Current Zoning: UMUD-O (uptown mixed use development, optional)  
Proposed Zoning: UMUD-O SPA (uptown mixed use development, optional, site plan amendment)

Approximately 3.23 acres located along the northwest side of North College Street and both the east and west sides of East 7th Street.

The petition proposes a site plan amendment to approved rezoning petition, 2021-163. This rezoning would amend the existing conditional plan to add an additional vehicular access point and pedestrian connectivity.

RZ-N1

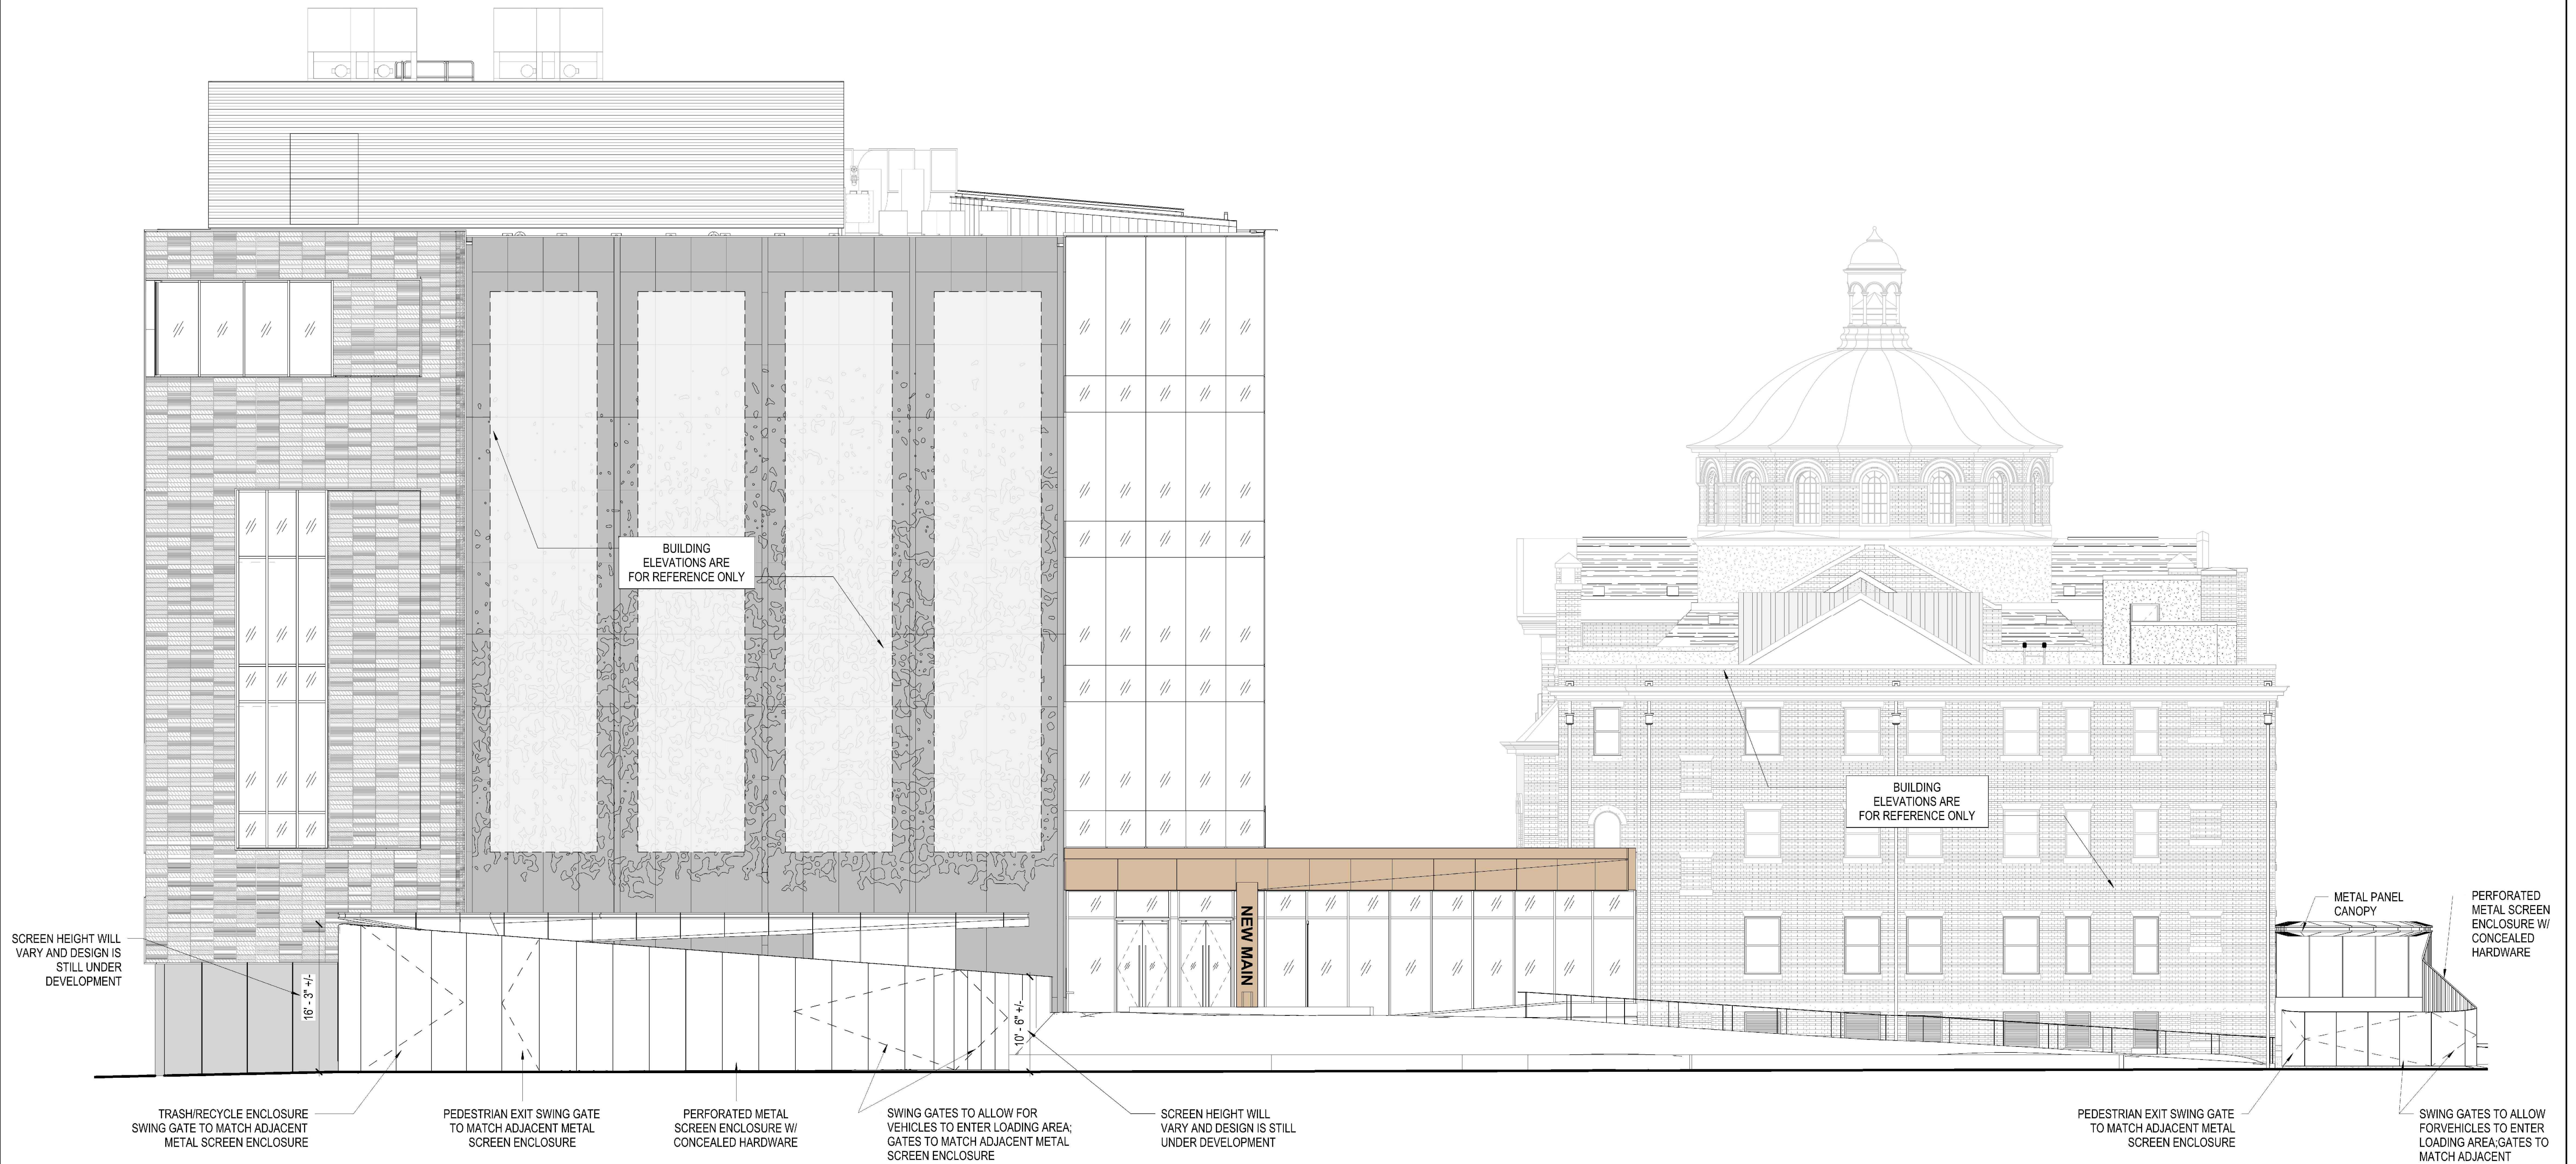
3. ~~On Sheet RZ-N1, revise the existing zoning to list UMUD-O and revise the proposed zoning to only list UMUD-O SPA.~~ **Addressed**
